East Anglia One North (EA1N) and East Anglia Two (EA2) Offshore Wind Farms

Planning Inspectorate Reference: EA1N – EN010077, EA2 – EN010078

Deadline 9 – 15 April 2021

Comments of Suffolk County Council as Local Highway Authority

TITLE
A1094/ B1069 WIDENING FOR ABNORMAL INDIVISIBLE LOAD

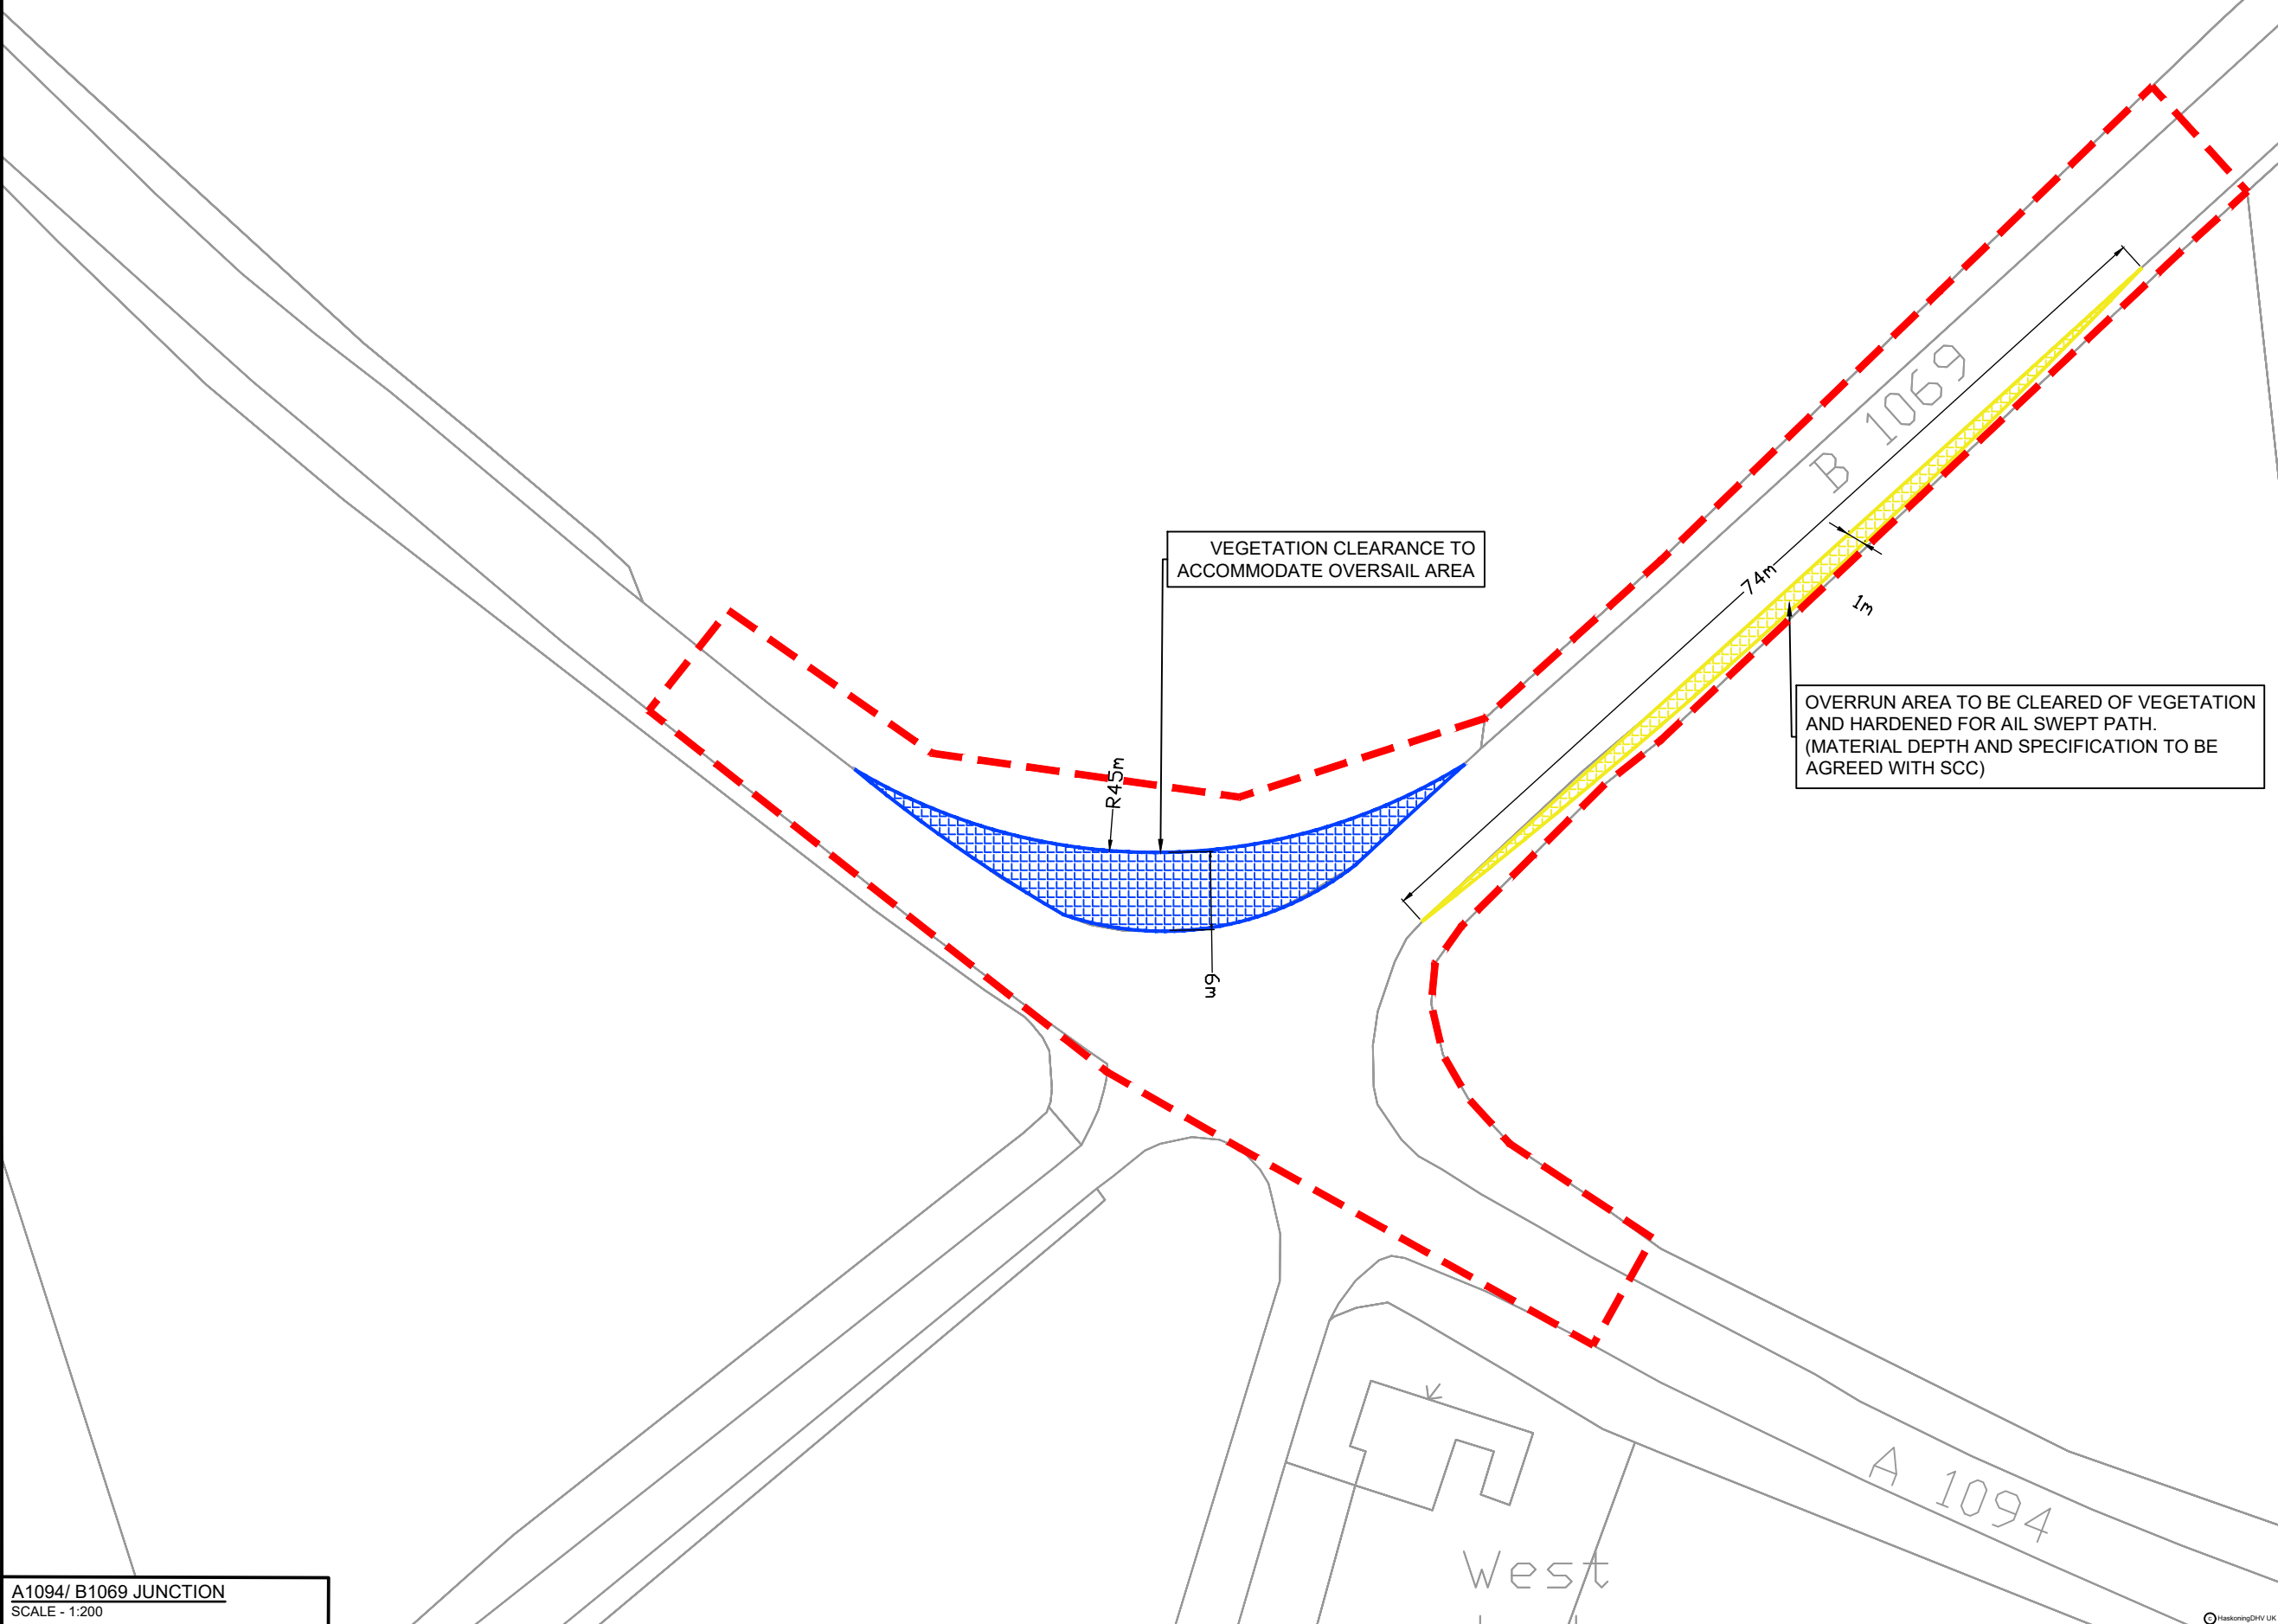
- 4.40 ID34: Acceptable.
- 4.41 ID35: The LHA's concerns remain that the improvements to the A1094/B1069 junction require delivery early in the construction program to avoid disruption

to the applicants' construction vehicles gaining access to the main site compound south of Knodishall.
